# **M60/M62/M66 Simister Island Interchange**

**TR010064**

## **7.13 APPLICANT'S RESPONSES TO RELEVANT REPRESENTATIONS**

<b>Version</b>	<b>Date</b>	<b>Status of Version</b>
P01	24 September 2024	Deadline 1

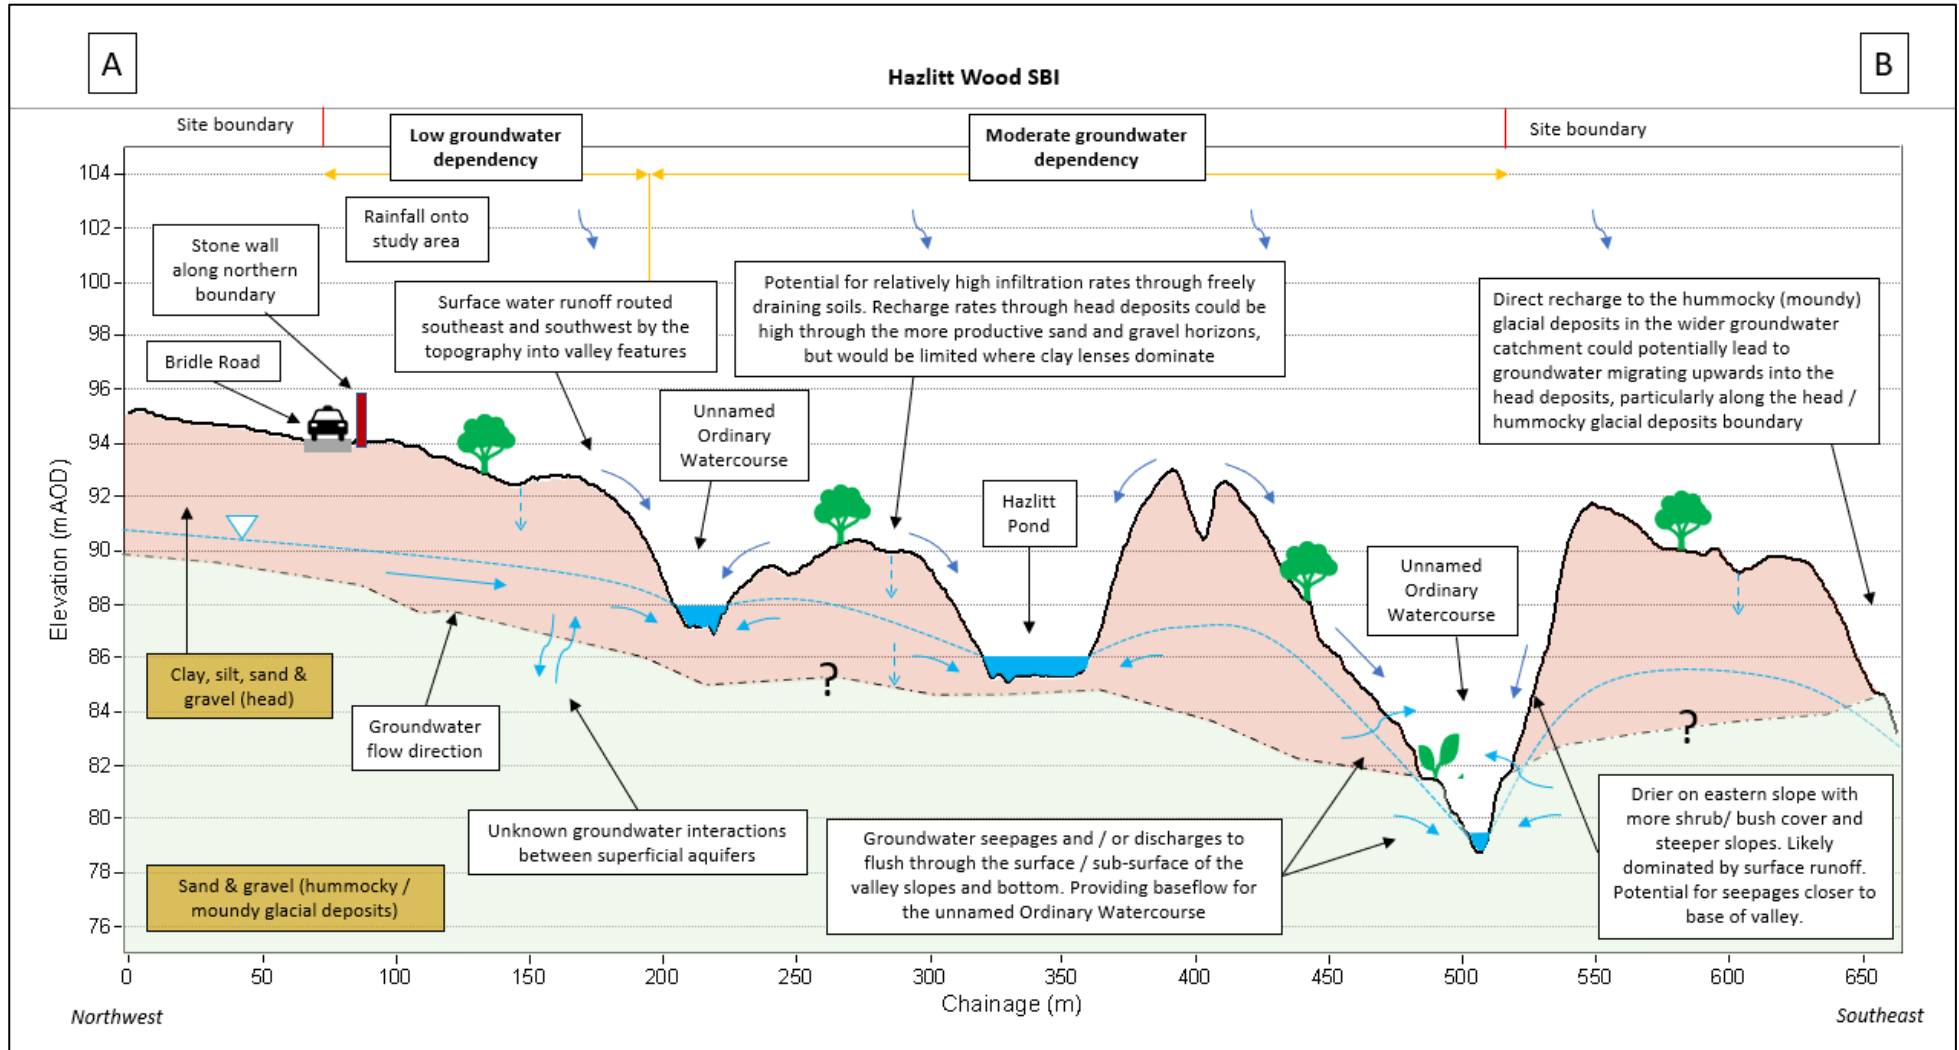
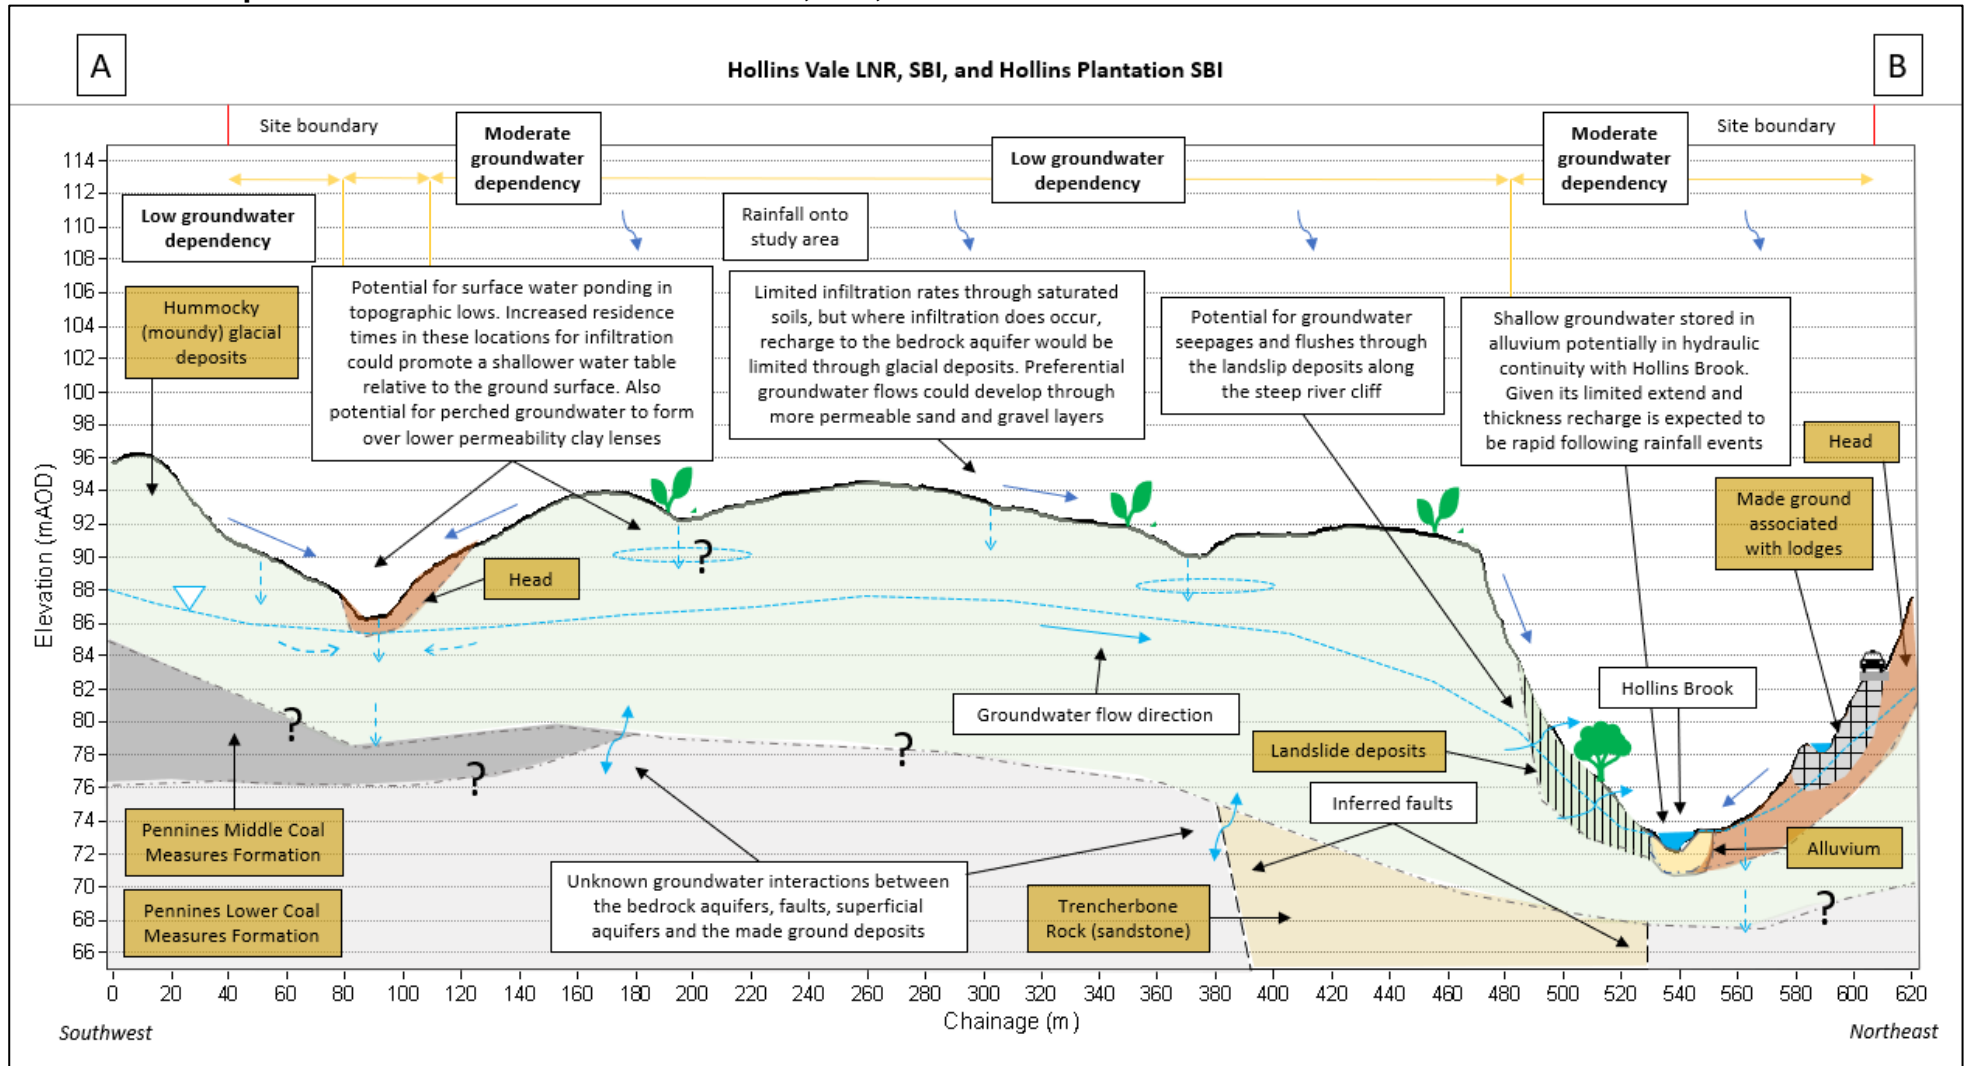
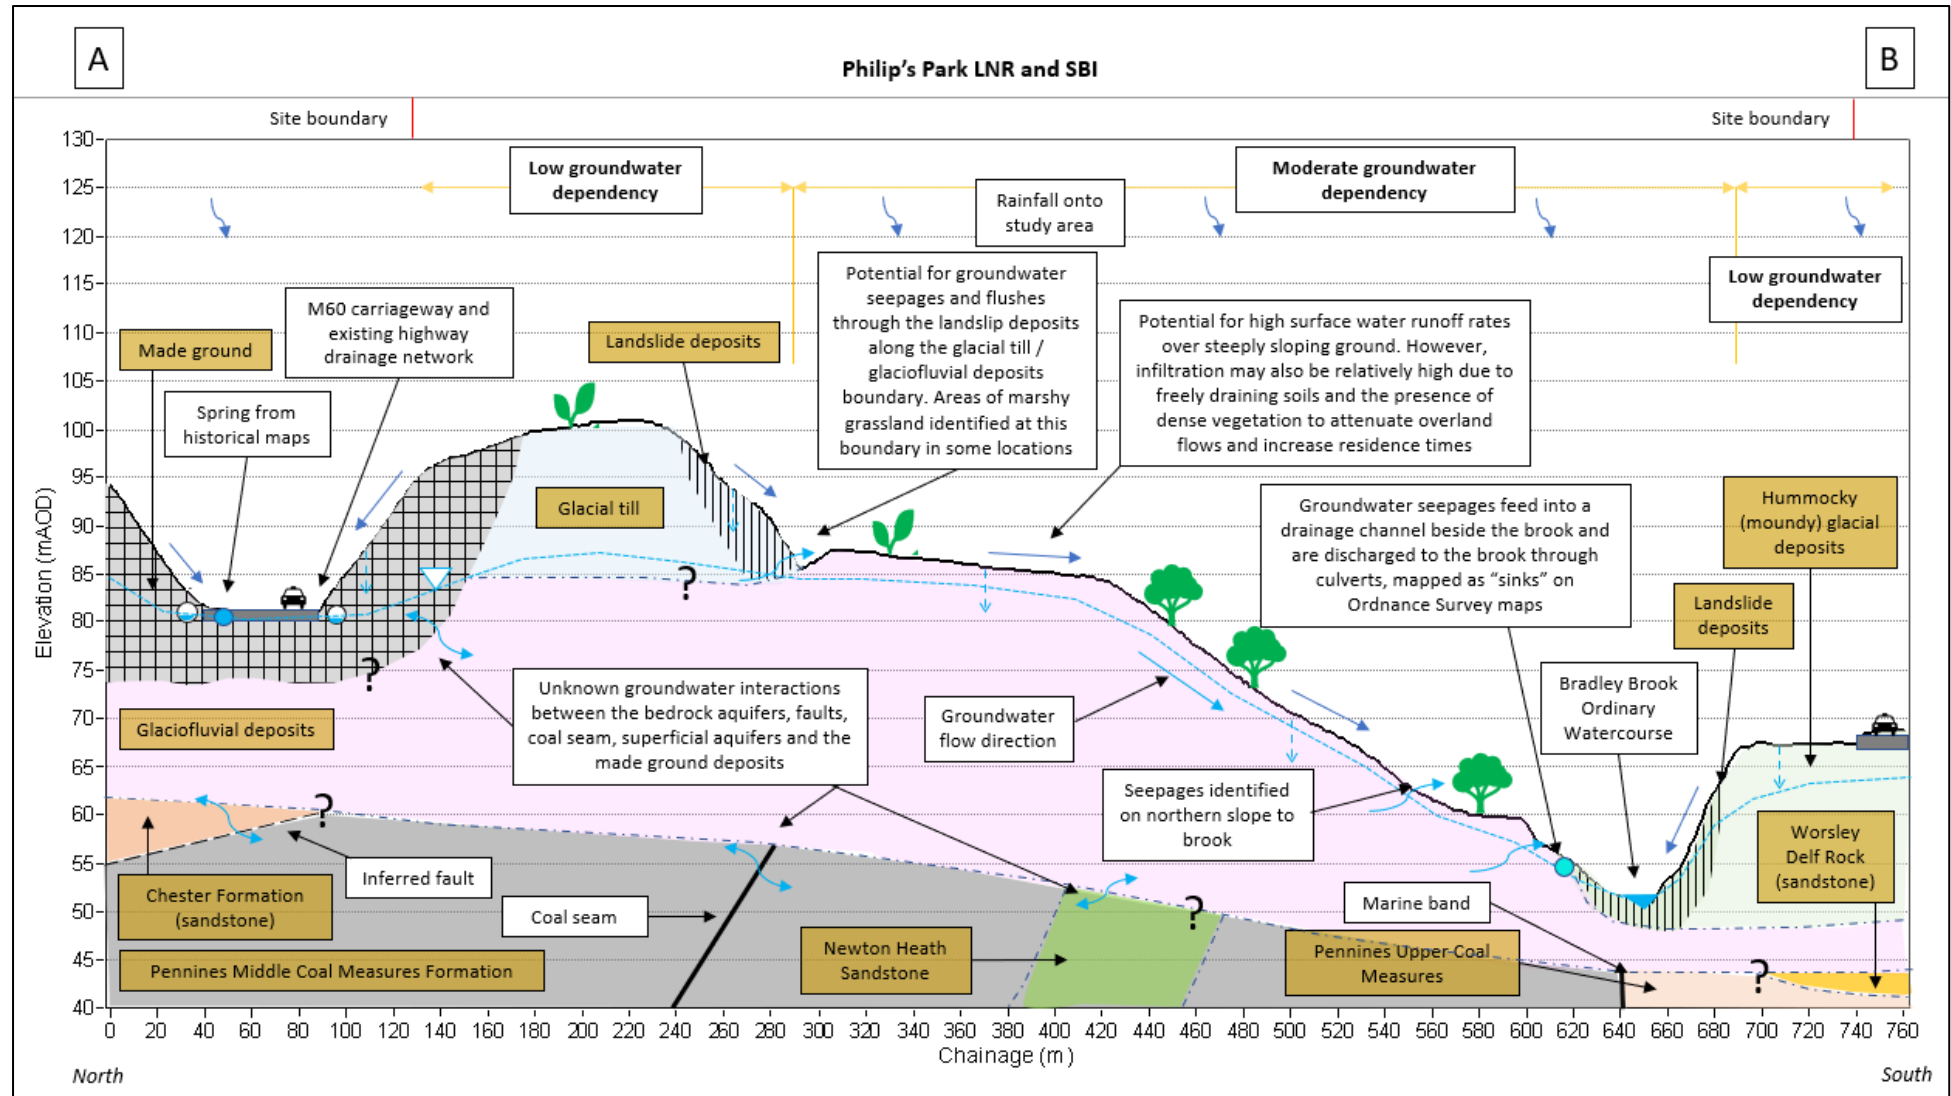
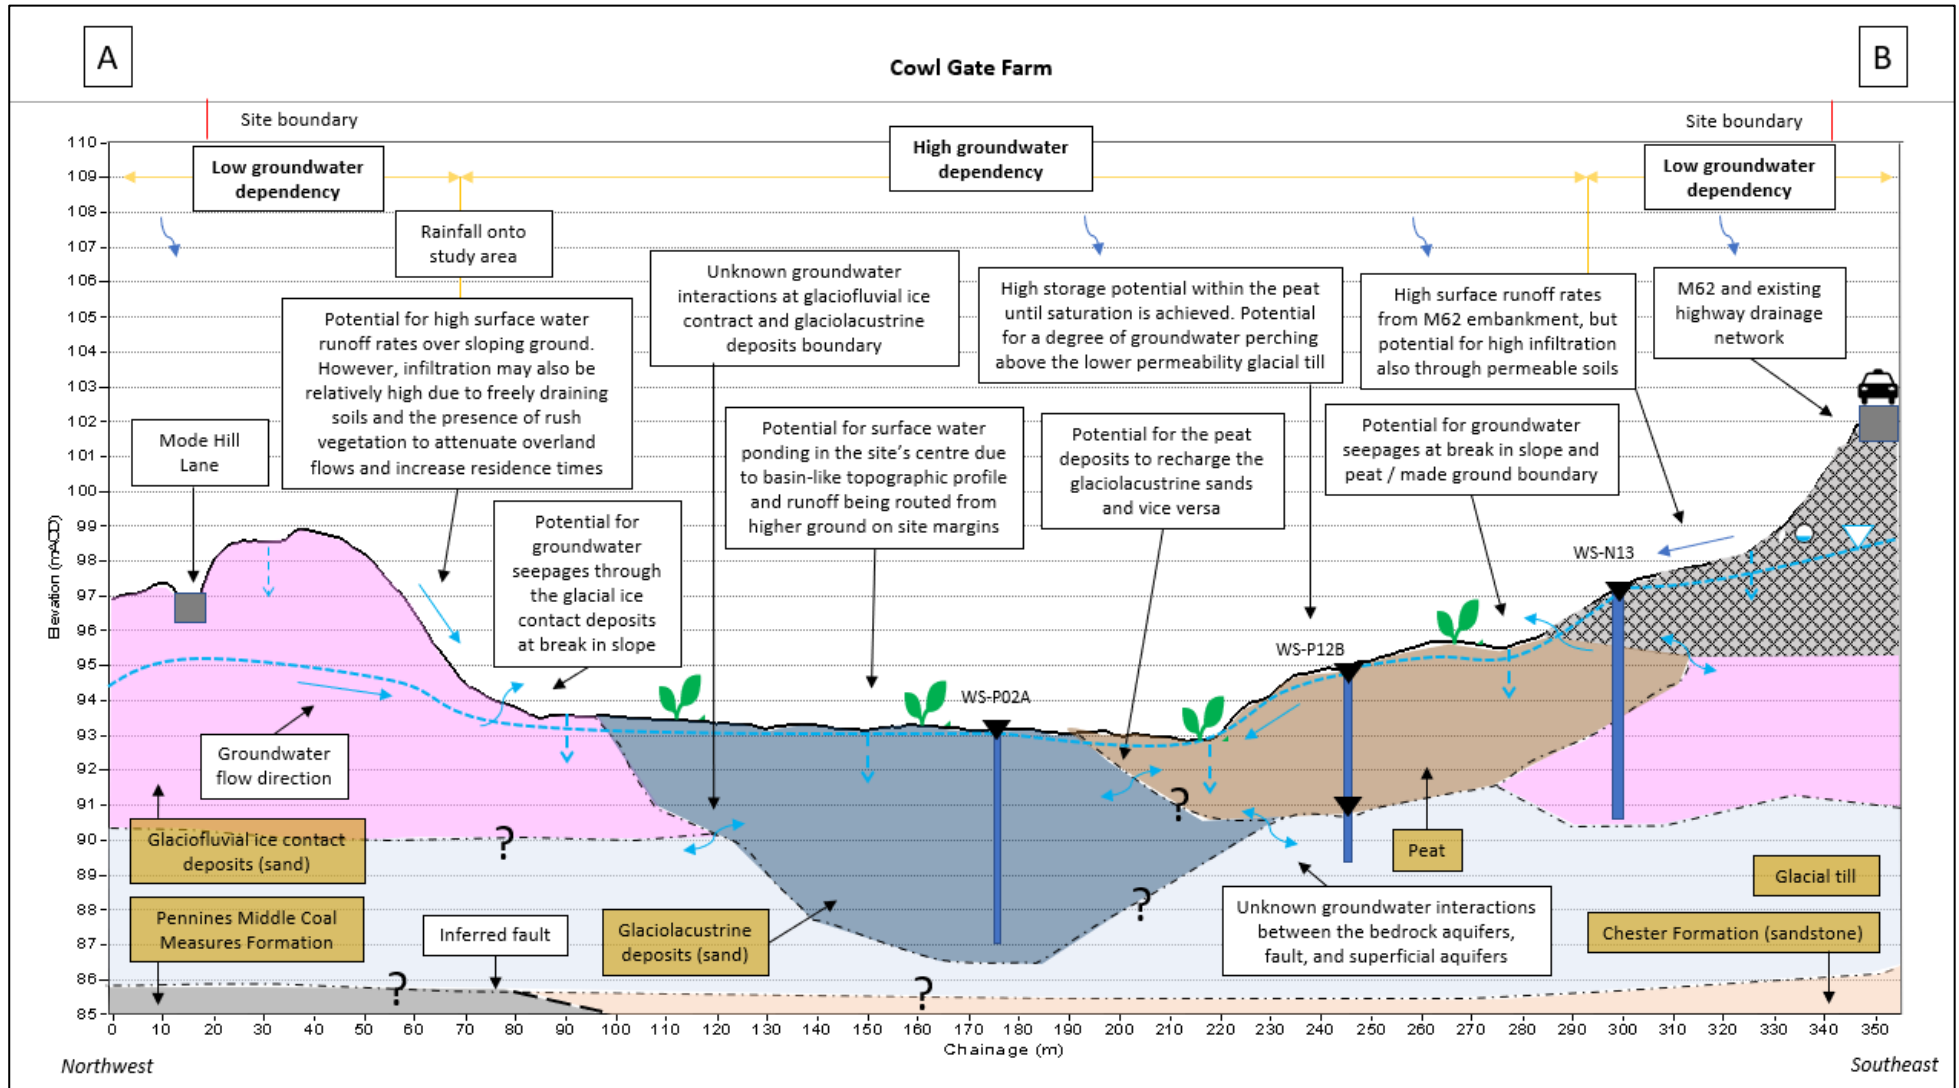
RR-004e	<i>The conceptual models have shown that there are connections with the groundwater dependent terrestrial ecosystems as shown in the report. The HERWAT assessment considered in Appendix 13.2: Water Quality Assessment Report of the Environmental Statement Appendices (TR010064/APP/6.3) does not look at impacts to groundwater. If any changes are made and discharges are to be made to groundwater, then a water quality assessment must be completed in line with the SUDS manual (C753) to determine the risks and mitigations required for groundwater quality. This is especially important because of the presence of nearby groundwater dependent terrestrial ecosystems.</i>	Please refer to the response provided in the agreed Statement of Common Ground with the Environment Agency [TR010064/APP/7.11].
RR-004f	<i>We note under Chapter 9 (Geology and Soils) of the Environmental Statement that there is an intention to produce a Detailed Quantitative Risk Assessment (DQRA) to establish risks of contamination from the proposed development to 'controlled waters'. Following the production</i>	Please refer to the response provided in the agreed Statement of Common Ground with the Environment Agency [TR010064/APP/7.11].
